CITY OF PORTLAND, MAINE

July 26th, 2011

Project Name: Harborview Townhomes
New building comprising 7 residential units
(19 space parking lot shared with existing 12 unit residential building)
Project ID: 2011-214
Project Address: 127 York Street (aka 121-129 York Street)
CBL: 44 - A-004/005

TO: Jean Fraser, Planner
FROM: David Senus, P.E. & Ashley Auger, E.I.T.
DATE: June 23, 2011
RE: Harborview Townhouses, Level III Final Site Plan Application

NOTE:
SEE CIVIL DRAWINGS FOR
GRADING AND STORMWATER
MANAGEMENT.

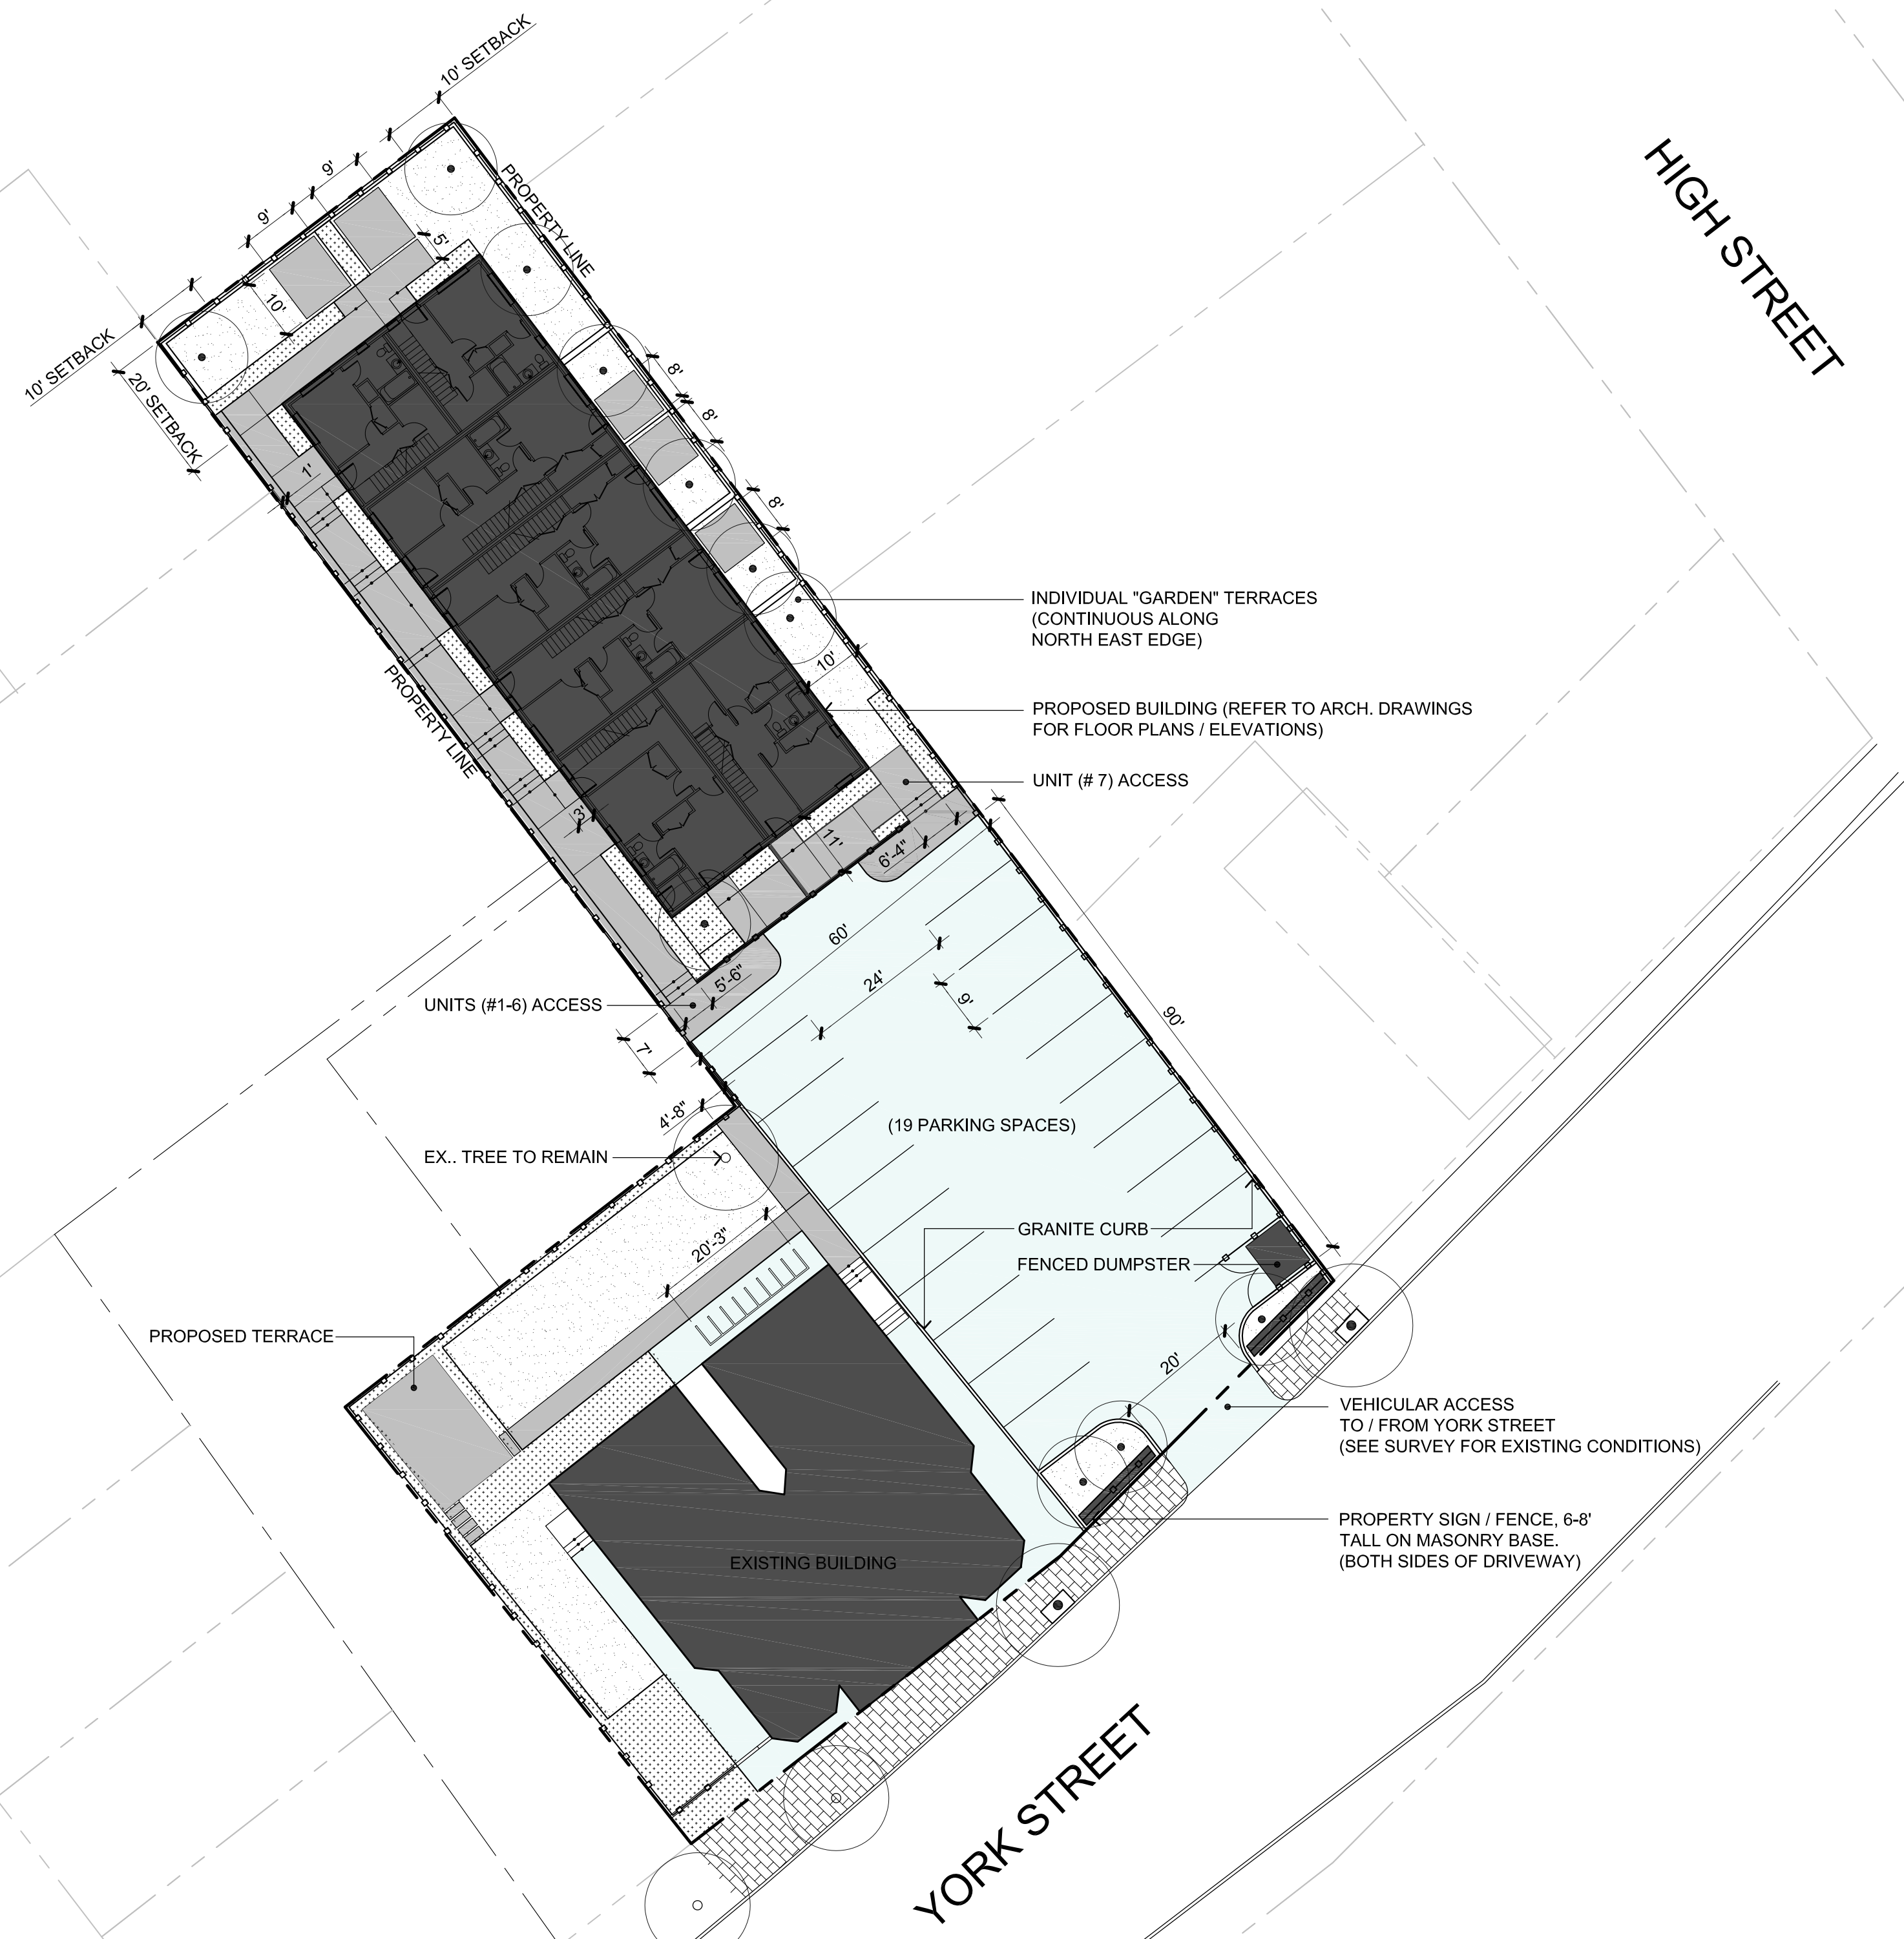
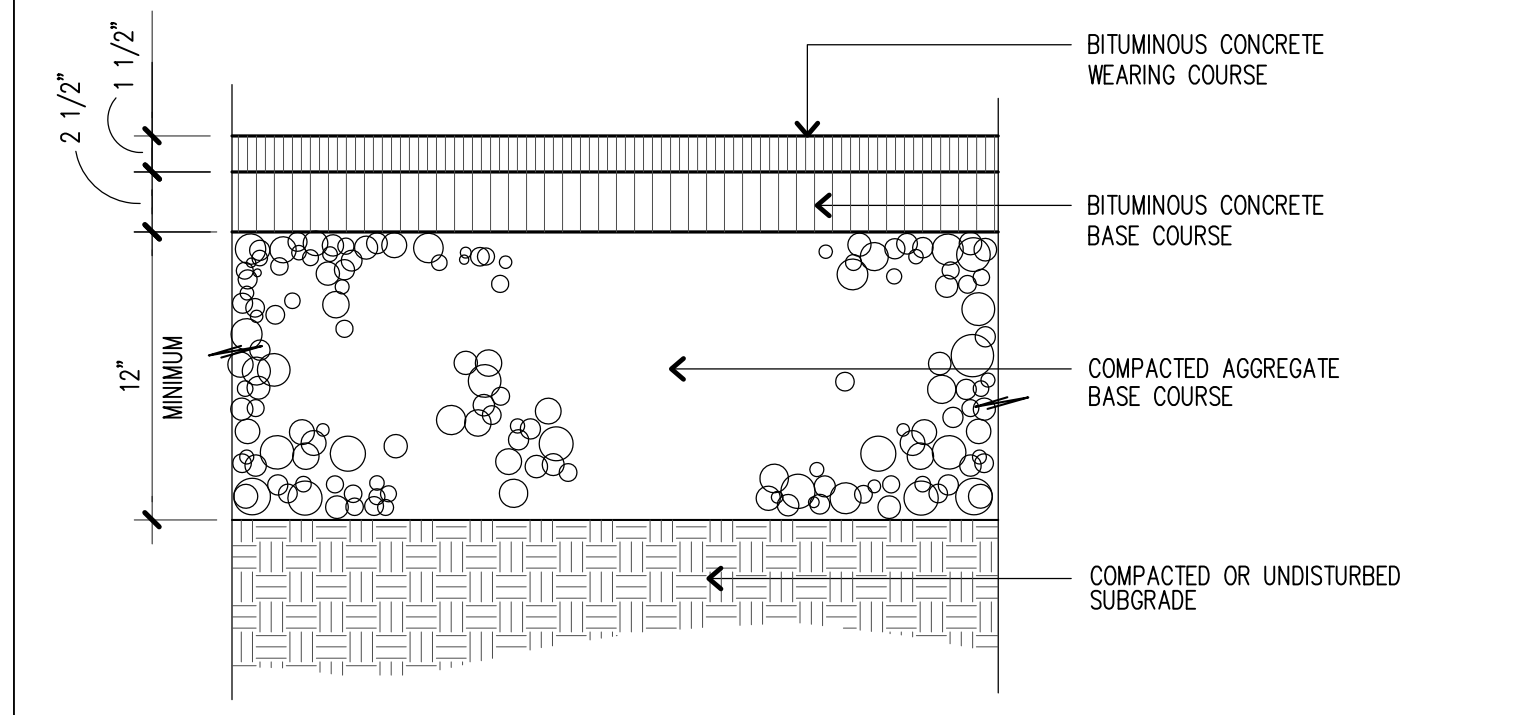
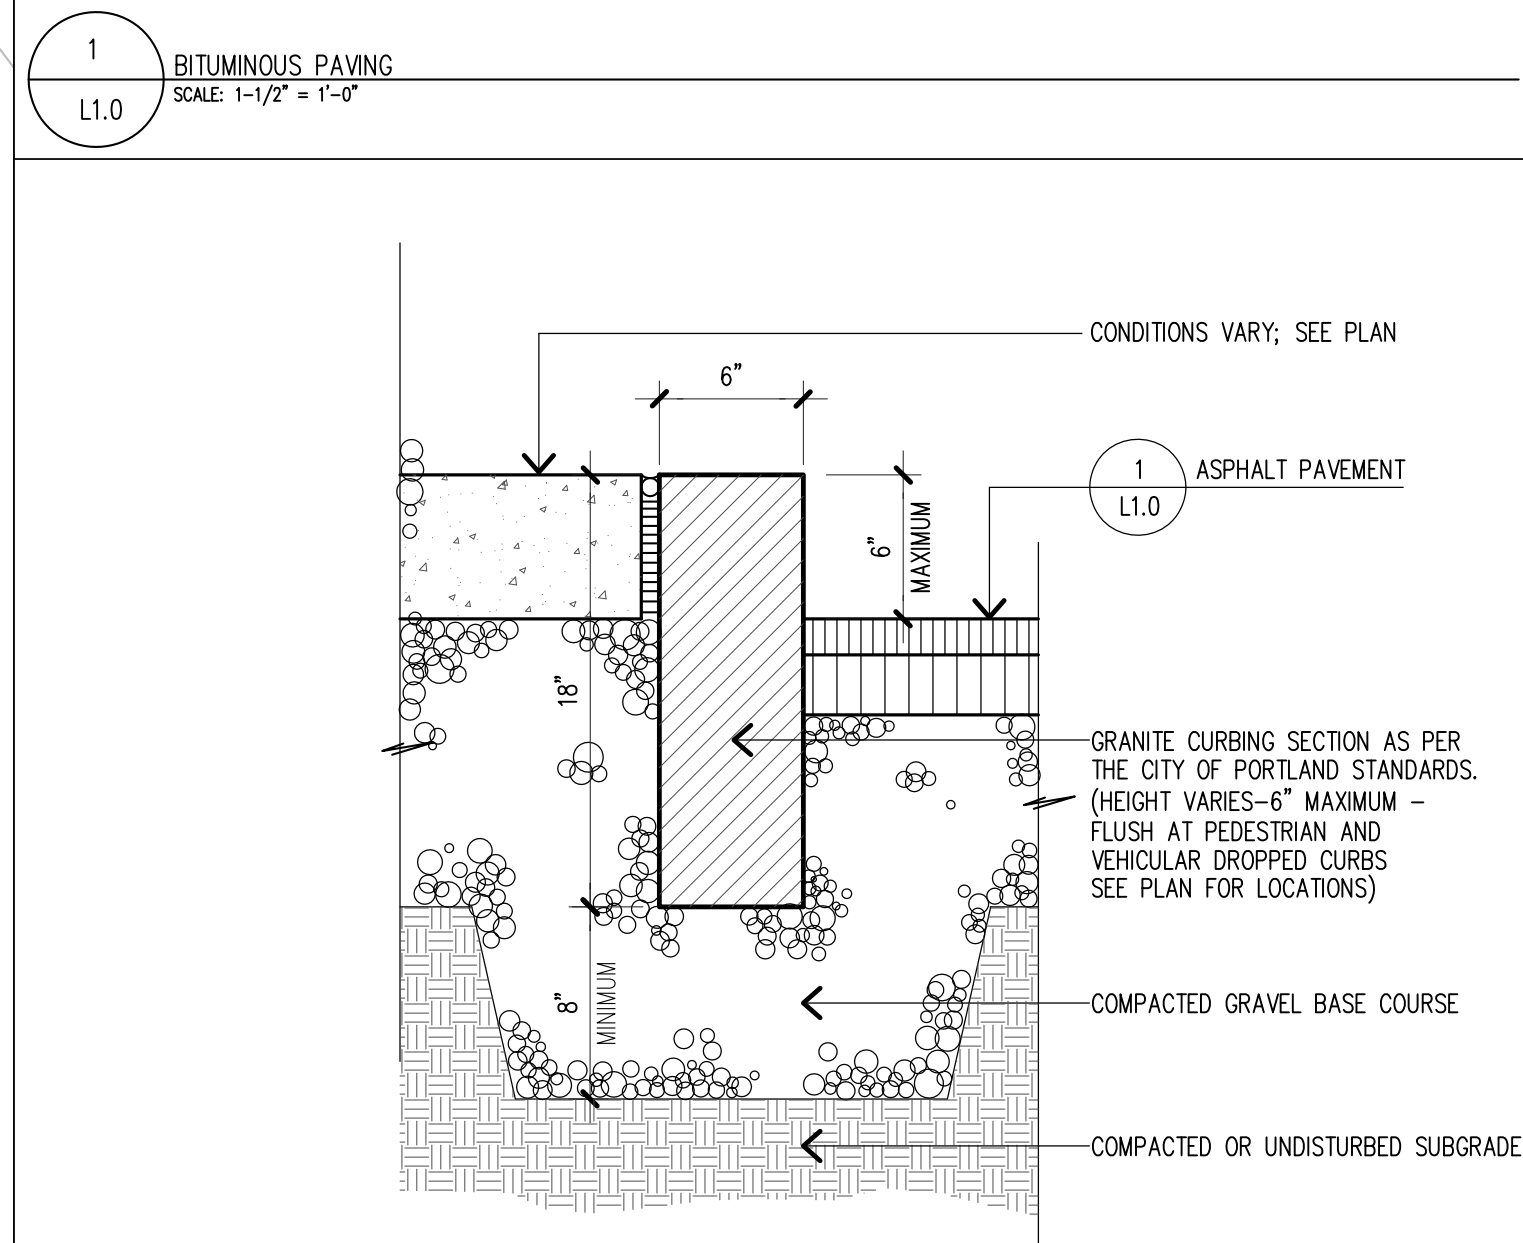
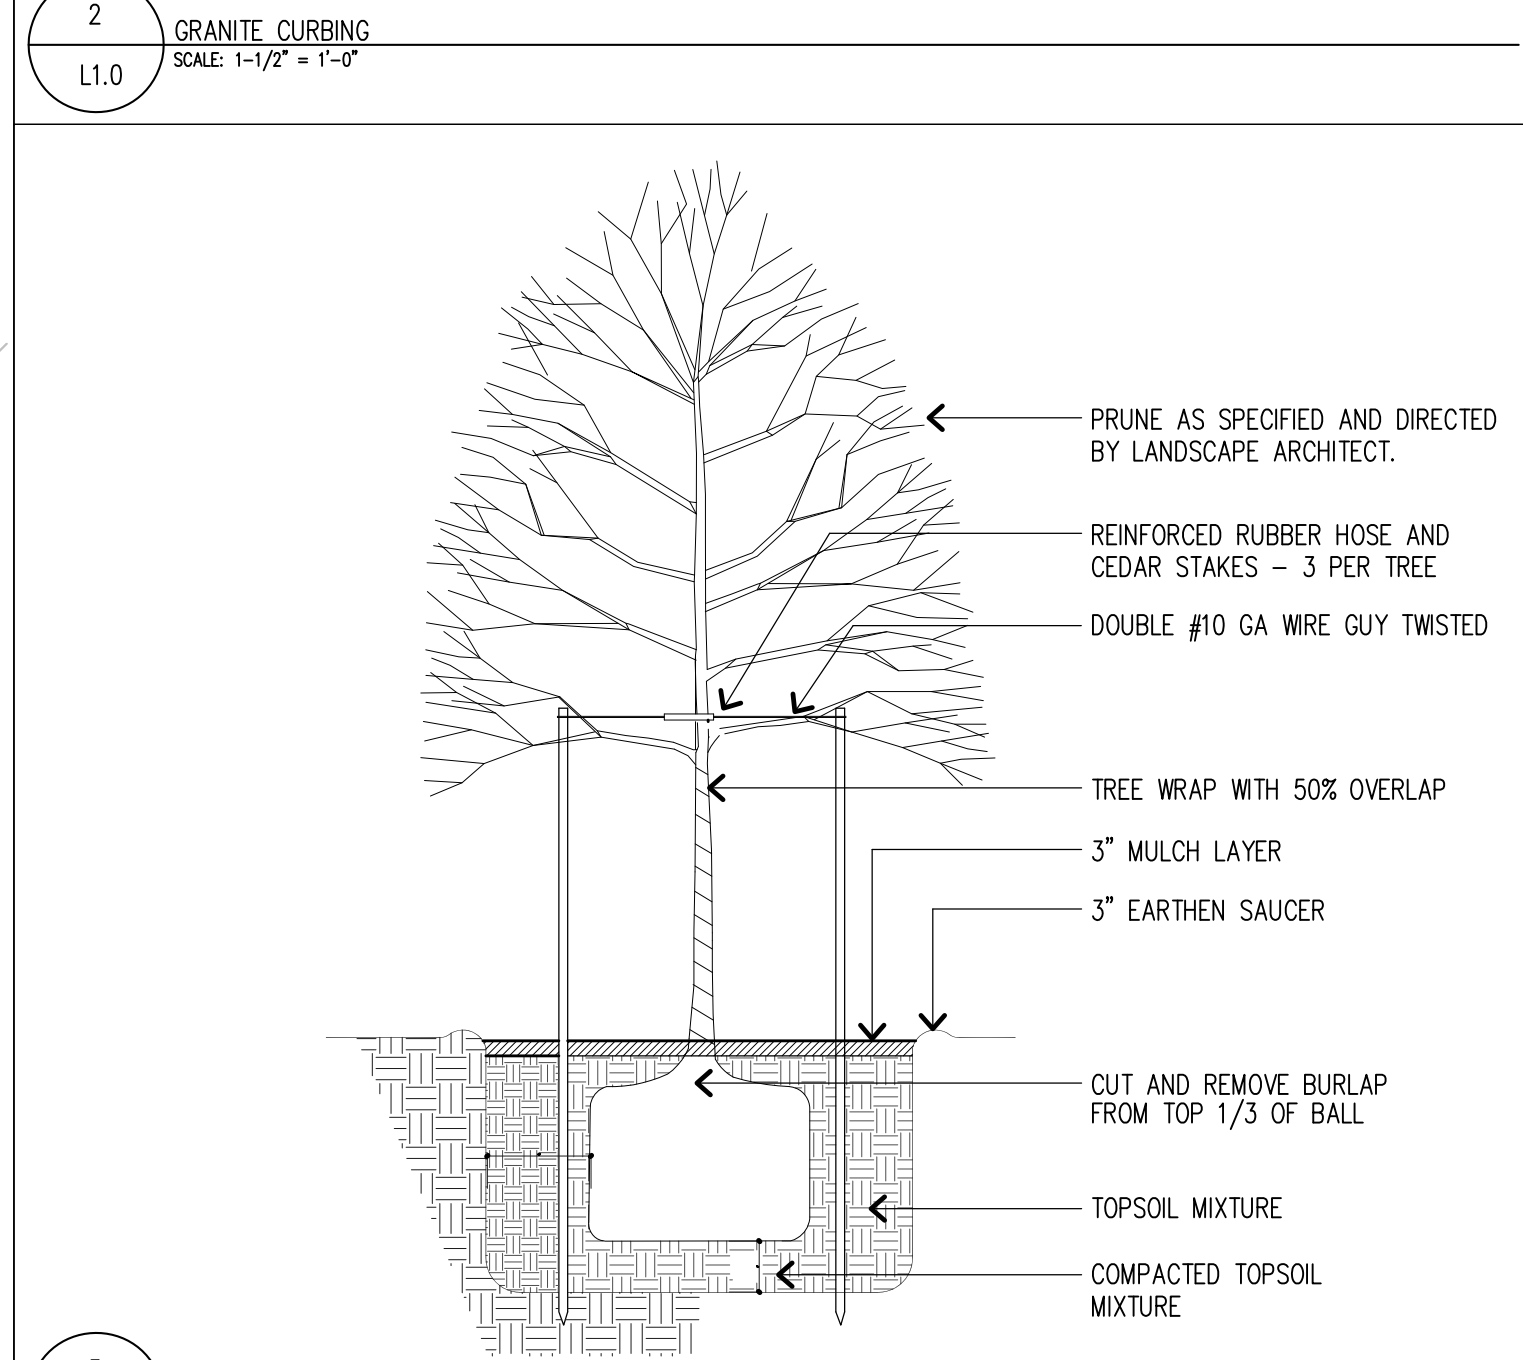
a) Landscape plan - the landscape plan, shown on sheets L-1.0 L-2.0 and L-3.0 should include a plant key or schedule that lists botanical and common plant name and location on the plan. While Sheet L-1.0 does show a Symbols Legend with plant names it would be good to have a more detailed plant key or schedule, Sheet L 1.0 shows (8) Amelanchier SP (1.75" CAL.) and (8) 'Armstrong' Red Maple (2.5" CAL.) with the later showing a larger graphic symbol finding the actual trees on the sheet could be clearer, I counted 17 circles or trees on design sheet and 16 trees on the Symbols Legend.

b) Tree Saves - the landscape plan Sheet L 3.0 shows details on tree protection, Sheet L 1.0 shows three trees, two along the sidewalk and one near the back corner of the existing building to be saved. The project should also take measures to protect trees on adjacent properties during site work, this would include root pruning exposed roots found during excavation and pruning any damaged limbs during construction. These items can be reviewed during the project 'Pre-Construction' meeting.

c) Street-trees & Parking Lot trees - The landscape plan includes two existing street trees along York Street and proposes to plant two additional trees ('Armstrong' Red Maples near the entrance driveway. The new street-trees are planted with tree grates, (Neenah R-8810 recommended) the location of tree on the right or High Street side of driveway may need to be adjusted to maintain sidewalk width for snow plowing and access. A second option would be to include this tree into the planting space with the other two trees. Parking Lot trees - the parking lot area contains 19 parking space creating a need for 10 trees to meet the Parking Lot Landscape Standard. The plan proposes six trees near the York Street entrance, three near the proposed building front and one near the existing building - which is "close". Ideally, one additional tree perhaps planted on the adjacent private property mid way up the right side of the parking lot would be a creative solution. It would help the parking lot standard and additional screening for the neighboring property.

d) Landscape treatment - In addition to the 'tree saves' and 'street & parking lot' trees the project mentions "planted landscape buffer" near the York Street entrance, 'individual garden terraces', 'raised planters along entry corridor', 'front patio garden' and two 'lawn' areas near the existing building are shown on Sheet L 2.0. Landscape treatment details, shrub and herbaceous landscape plant information and placement is needed on the plan. The landscape legend as shown does not mention any shrub planting.

- 1) Landscape Key / Plant List needed for trees, shrubs & herbaceous planting.
- 2) Tree Save - include tree protection measures to include 'off-site' trees.
- 3) Landscape Treatment, trees / shrub proposed for the areas shown as 'individual garden terraces', 'raised planters along entry corridor', 'front patio garden' should be included or shown in detail on the landscape plan.
- 4) to meet the standards of trees per unit and parking lot landscape three additional trees are needed.
